Appeal Decision

Appeal Ref: APP/R5510/W/21/3275115

68-76 Albert Road, West Drayton, UB7 8ES

- The appeal is made under section 78 of the Town and Country Planning Act 1990 against a refusal to grant approval required under Schedule 2, Part 20, Class A of the Town and Country Planning (General Permitted Development) Order 2015 as amended.
 - The appeal is made by Mr H Purewal, Purewal Property Ltd against the decision of London Borough of Hillingdon.
 - The application Ref 33654/APP/2020/2582, dated 19 August 2020, was refused by notice dated 17 November 2020.
 - The development proposed is creation of two additional floors above existing building to incorporate 4 x 1-bed flats (Prior Approval).
-

PROPOSED ELEVATION SHOWING RELATIONSHIP BETWEEN PROPOSED DEVELOPMENT AND NOS. 59 & 61 ALBERT STREET (1:100)

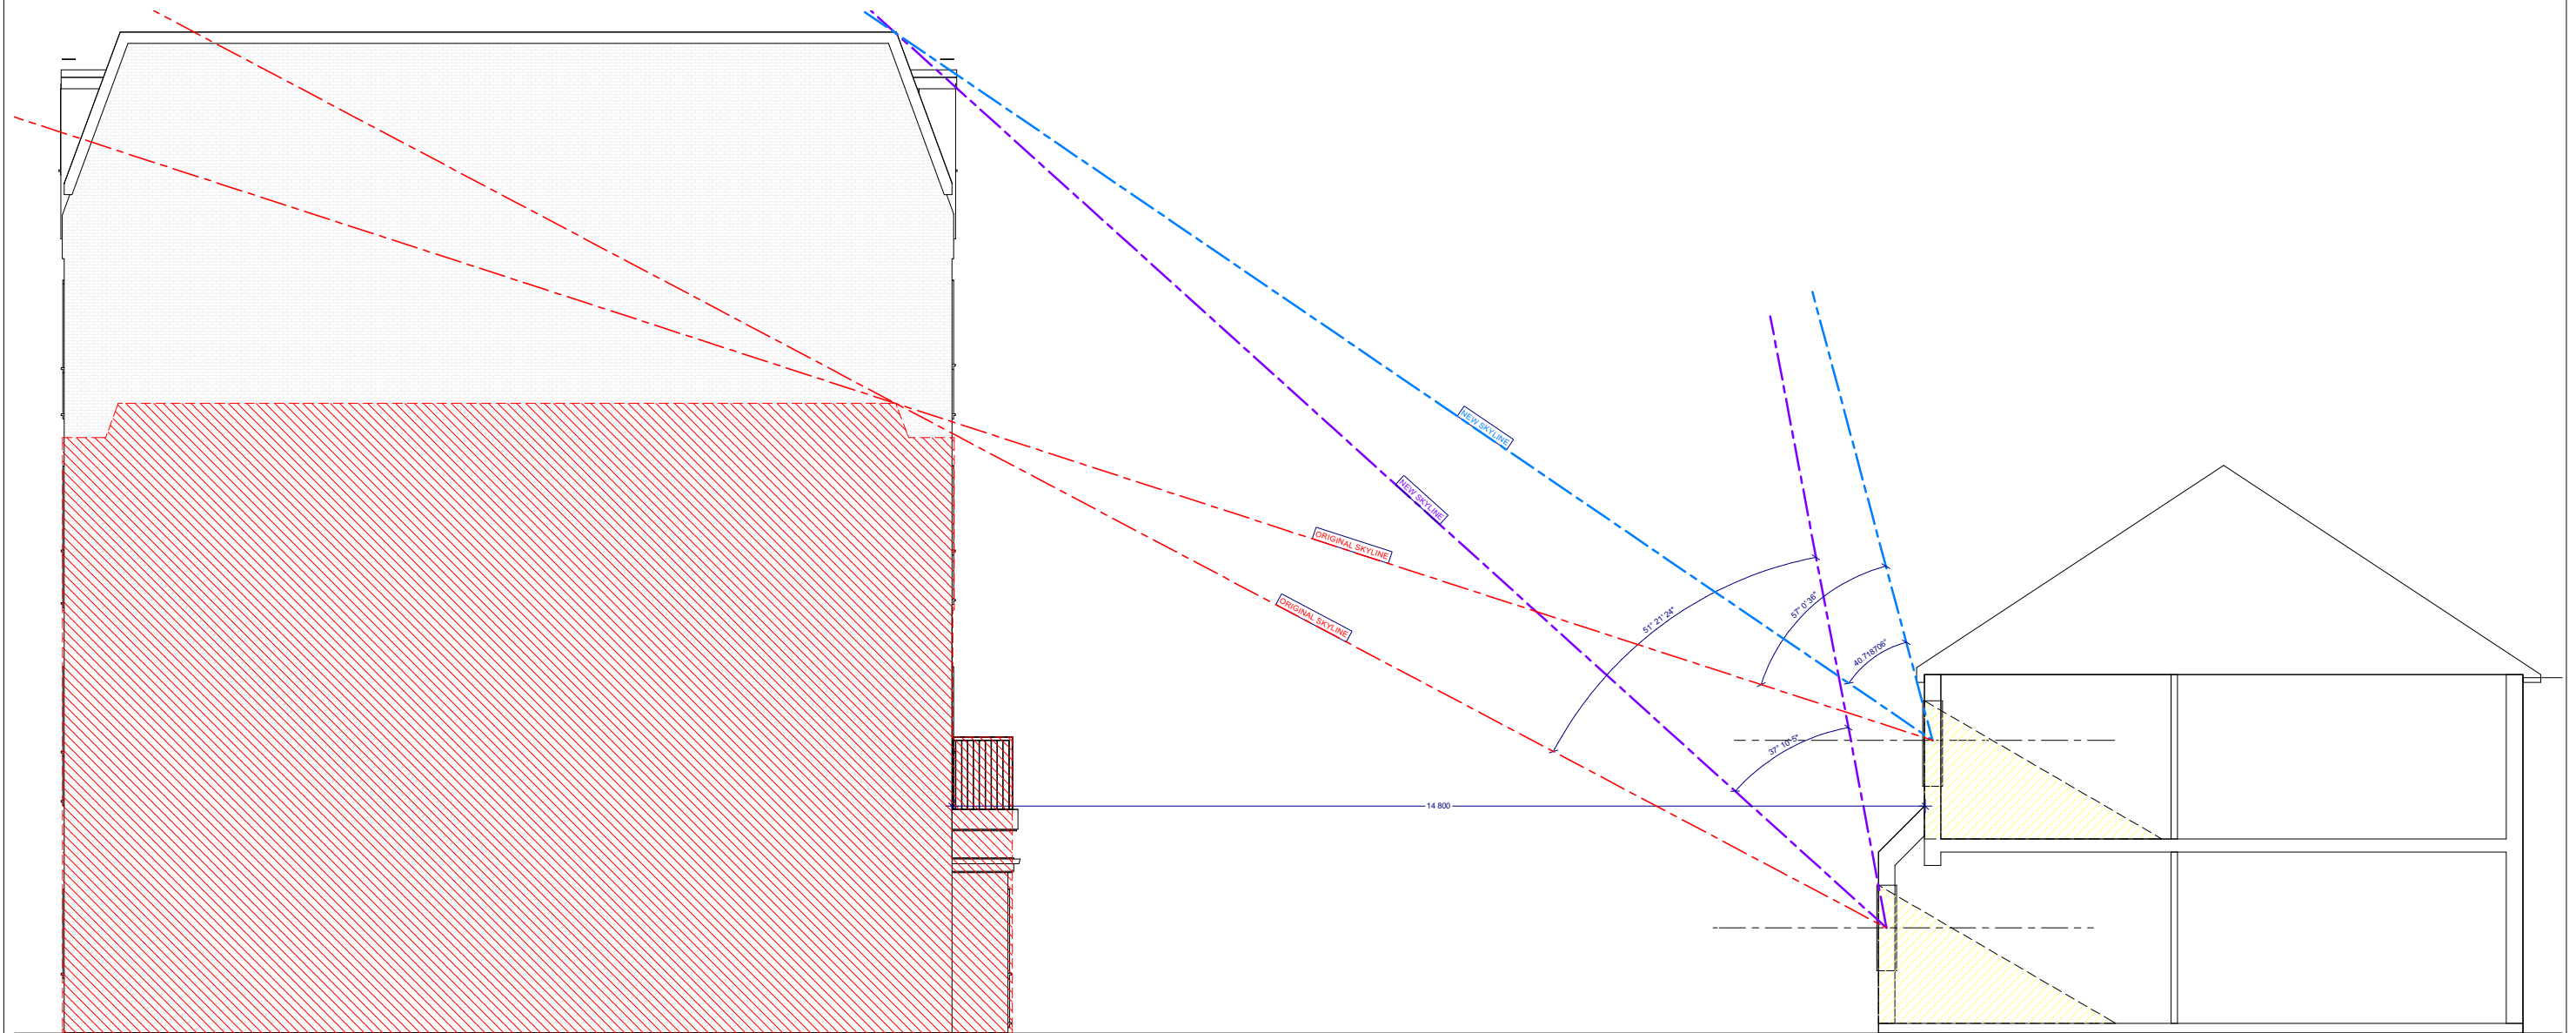
18. Opposite the appeal site are two storey houses Nos 59 and 61 Albert Street. These have main front windows facing the appeal site at ground and first floors. A.2(1)(g) indicates that account should be taken of the impact on the amenity and of neighbouring premises *including* (my emphasis) overlooking, privacy and the loss of light. This is not a closed list and, notwithstanding the

19. The carriageway and the footpaths on Albert Road are not particularly wide and the appeal building and the houses opposite are each set back a relatively short distance from the footpath. As a result I conclude that the height and mass of two additional floors above the three existing ones would unacceptably harm the outlook from windows at Nos 59 and 61, particularly those on the ground floors.

20. The appellant has provided some information which indicates adequate daylight and sunlight would remain available to the occupiers of Nos 59 and 61 should the extra floors be constructed. I have not seen all the detailed calculations that might normally accompany daylight and sunlight studies prepared in accordance with the BRE Trust "Site Layout Planning for Daylight and Sunlight" A Guide to good practice" (The Guide) and British Standards. However, even if I accepted the figures provided, I conclude that the harm to outlook would be such that the impact on the living conditions of occupiers of Nos 59 and 61 would be unacceptable.
